**Sydney CBD and South East Light Rail Project - Sydney Swans Limited (SSL) submission**

We refer to the Environmental Impact Statement for the CBD and South East Light Rail Project and ongoing briefings provided by TfNSW, particularly related to the Moore Park East precinct. As such, we acknowledge that the EIS differs to the preferred proposal now under consideration for Moore Park East.

Tramway Oval Baseline – Final State

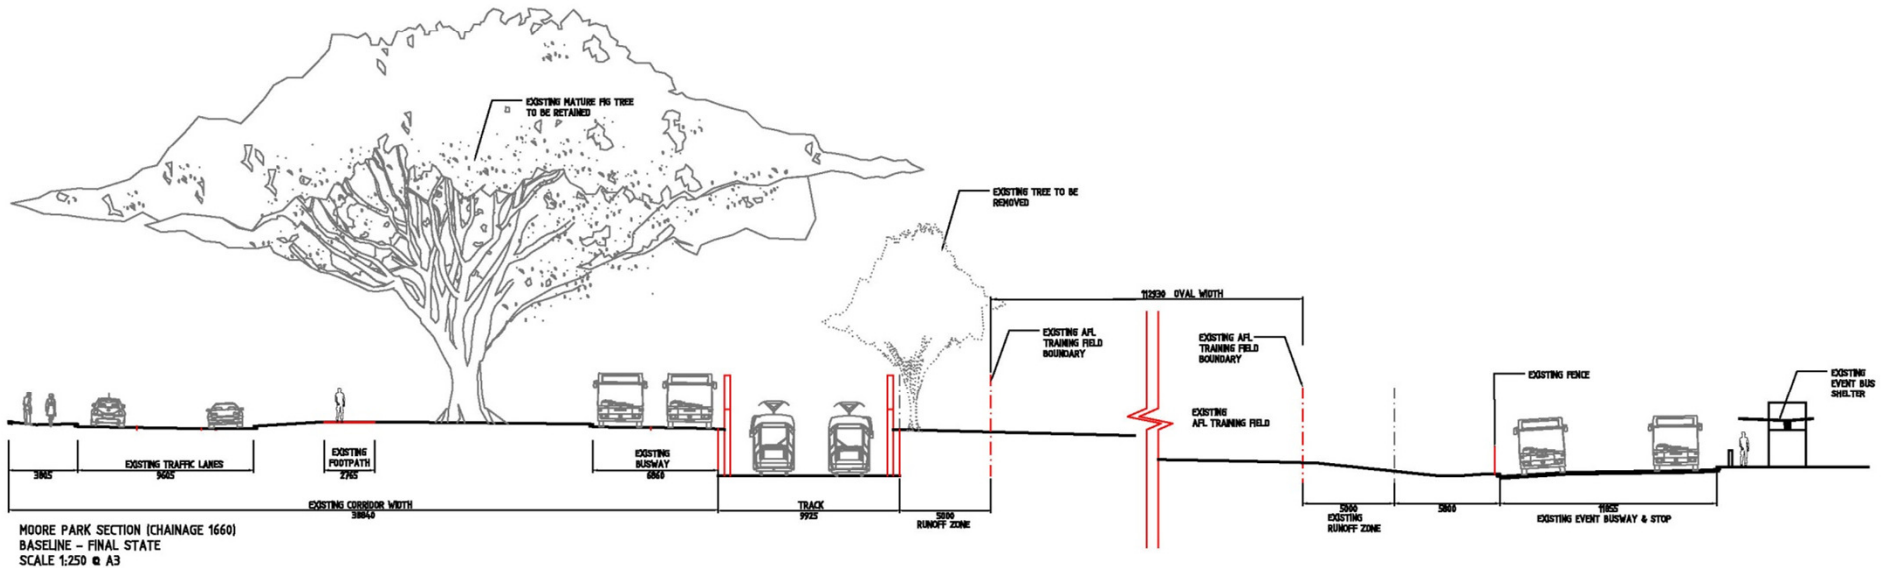
- SSL can not accept the width of Tramway Oval being impacted by 13 metres during construction, with a reduced training width remaining post construction.
- SSL do not support the Bus Loop Event service road remaining as a daily Bus road post construction. This would isolate Tramway Oval inside a transport hub and significantly impact accessing the field and user safety during training.
- SSL would support extending the Oval to the east pre commencement of the CSELR Project in order to limit the construction zone footprint on the western boundary. The impact of a reduced training width (projected 7m) during peak construction would be offset by a slight increase in overall field width post construction (~4.5m).
